Application No: CM/18/21/PL  
Site Address: Land adj Mistletoe Farm Horsemere Green Lane Climping BN17 5QZ  
Description of works: Erection of 1 No. 3 bed dwelling. This application is within CIL Zone 3 and is CIL liable as new dwelling.

Thank you for your internet representation made on 20th May 2021 which has been recorded as an objection with the comments as follows:

Clymping Parish Council objects to this planning application on the basis that there is inadequate space on the small plot which cannot accommodate the size and footprint of the proposed substantial chalet house.

sheet 2 of 3

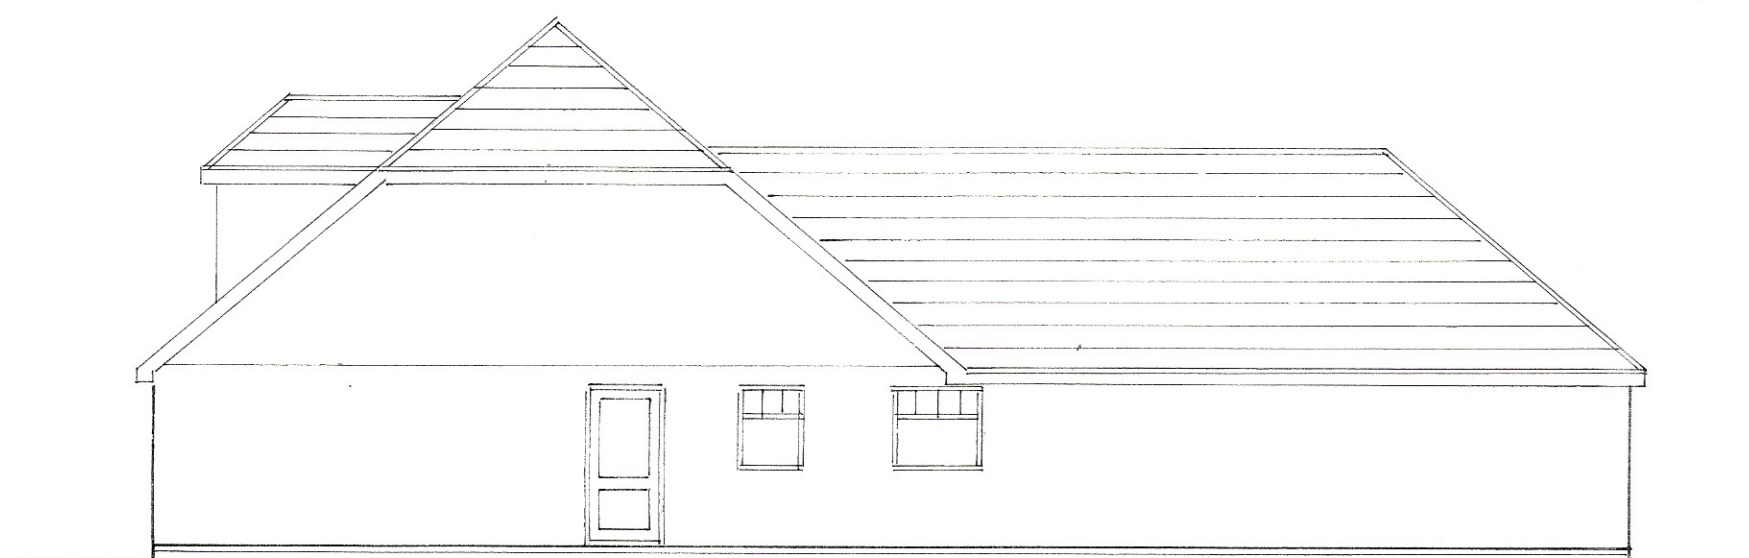
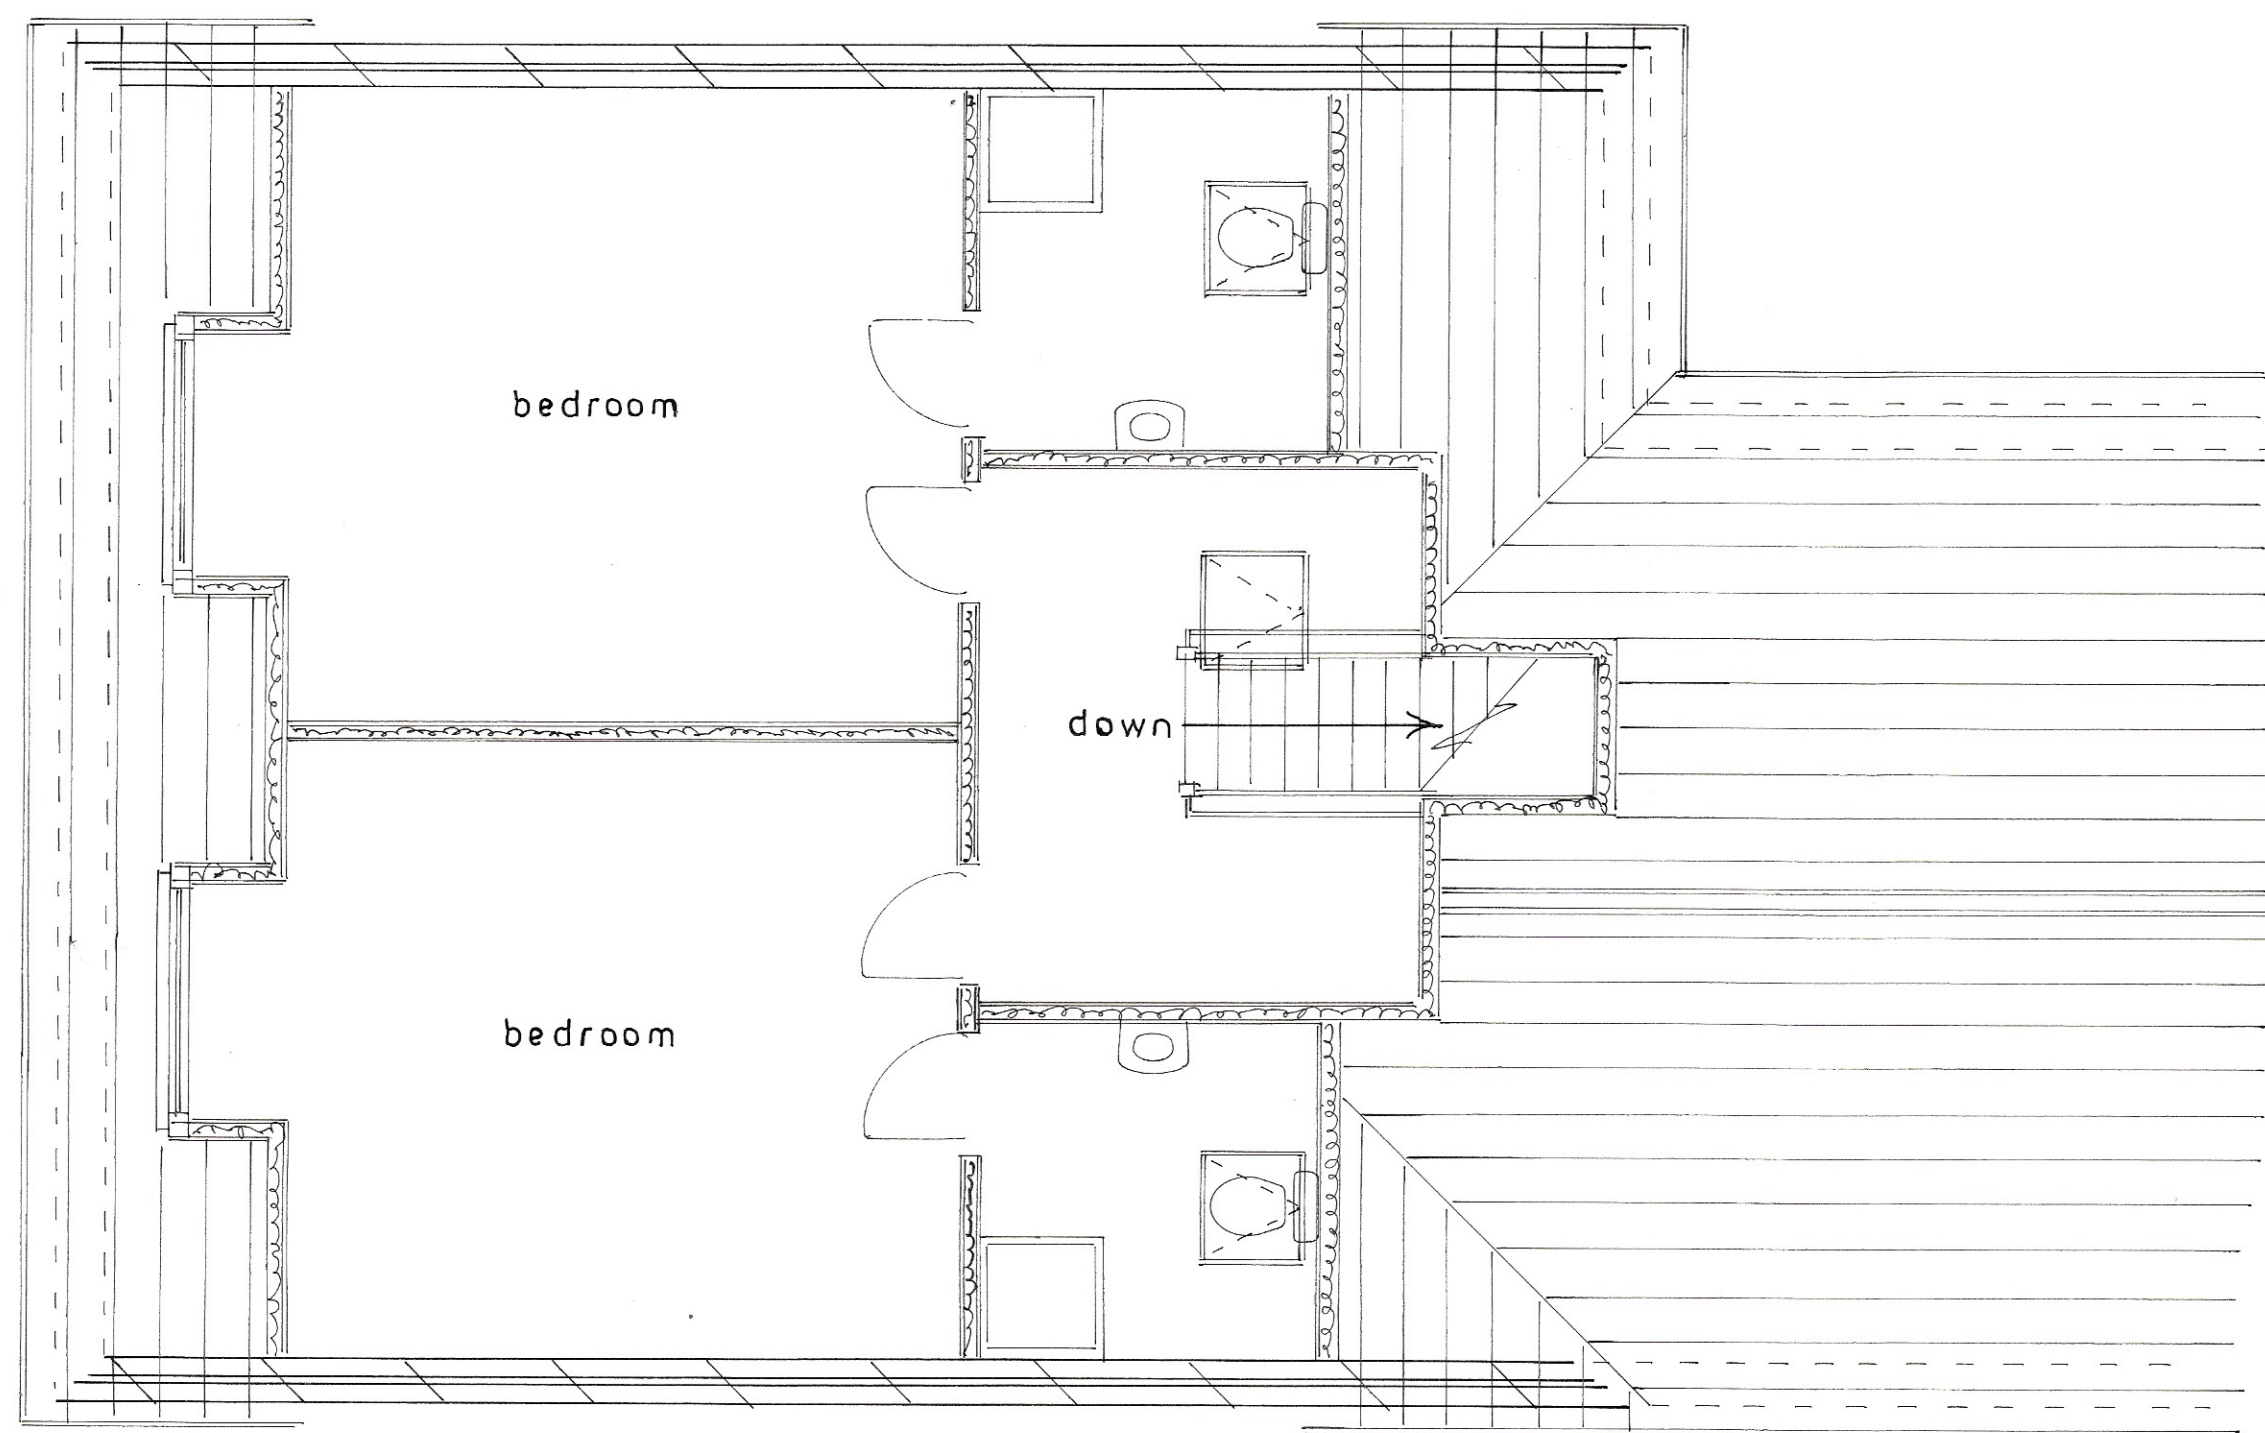
Clymping Parish Council draws the attention to the level of overlooking from the proposed upstairs windows onto the neighbouring properties and gardens which would adversely impact the open outlook from the neighbouring property.

However, should this application be approved, it is suggested that the upstairs windows should be conditioned to be obscured and fixed / restricted opening.

sheet 1 of 3

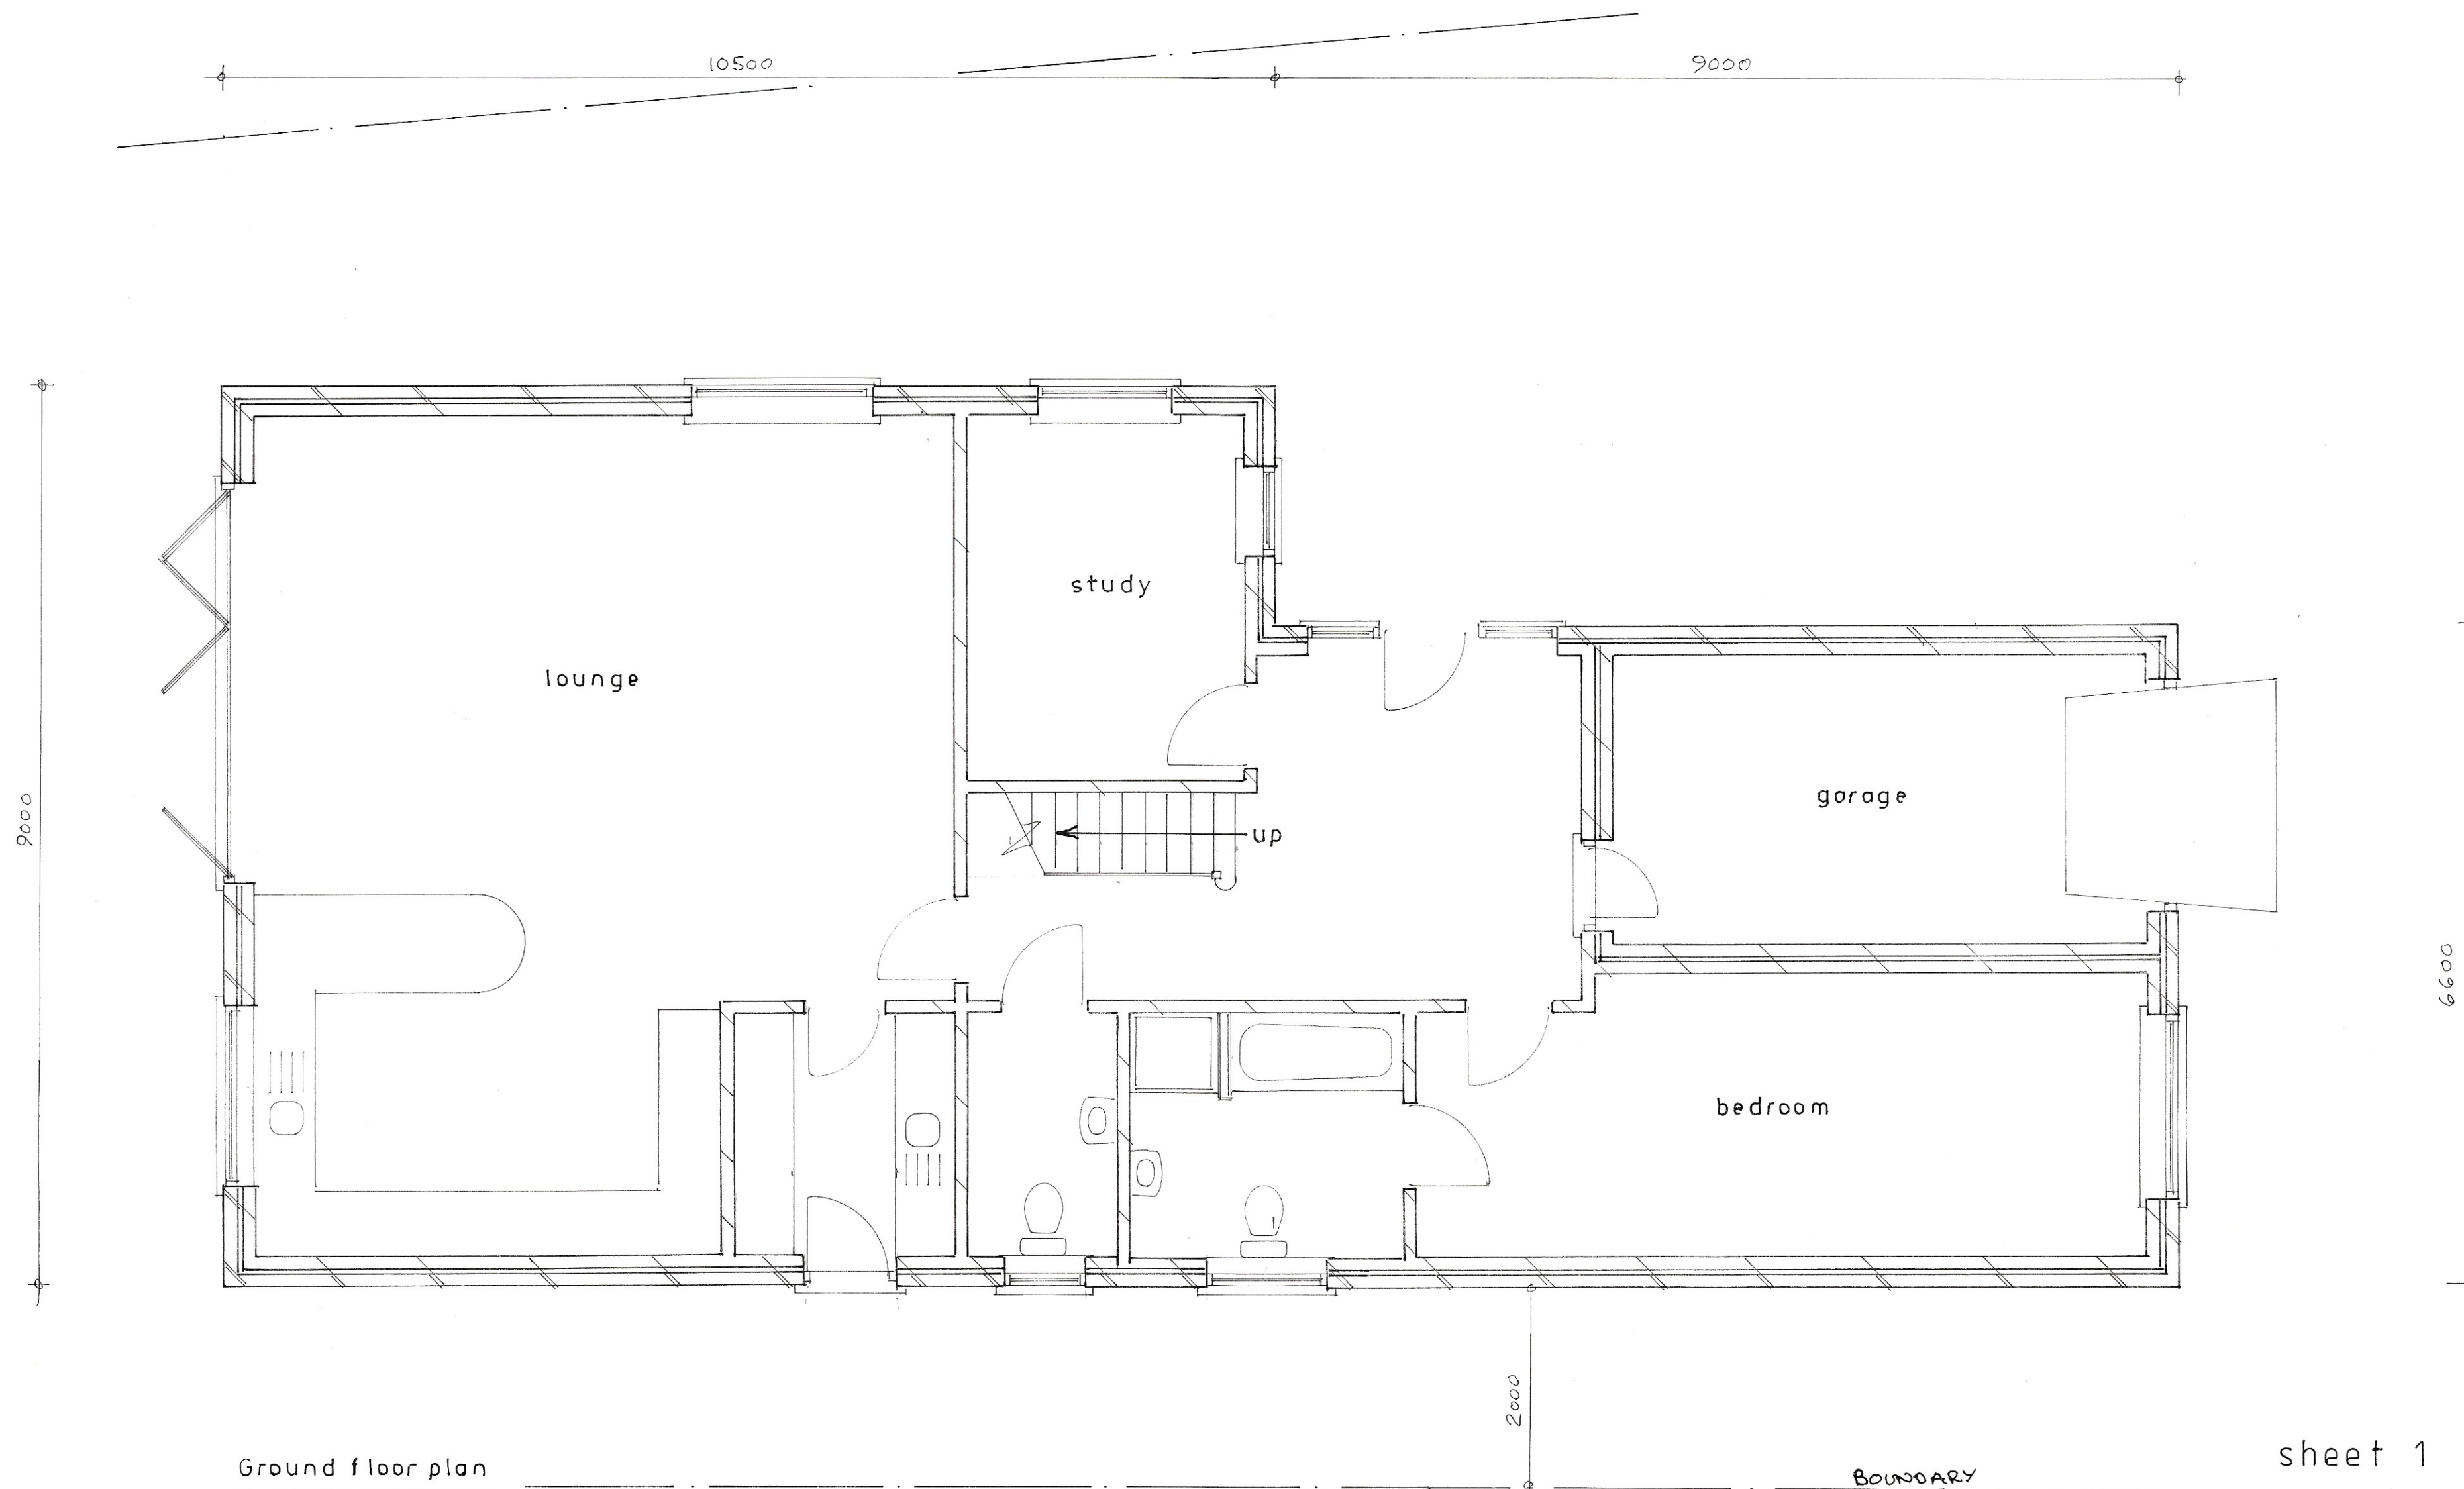
In relation to the access, the proposed driveway exits onto an already busy road (Horsemere Green Lane) and within a few metres from a junction creating a potential safety issue with restricted visibility in both directions.
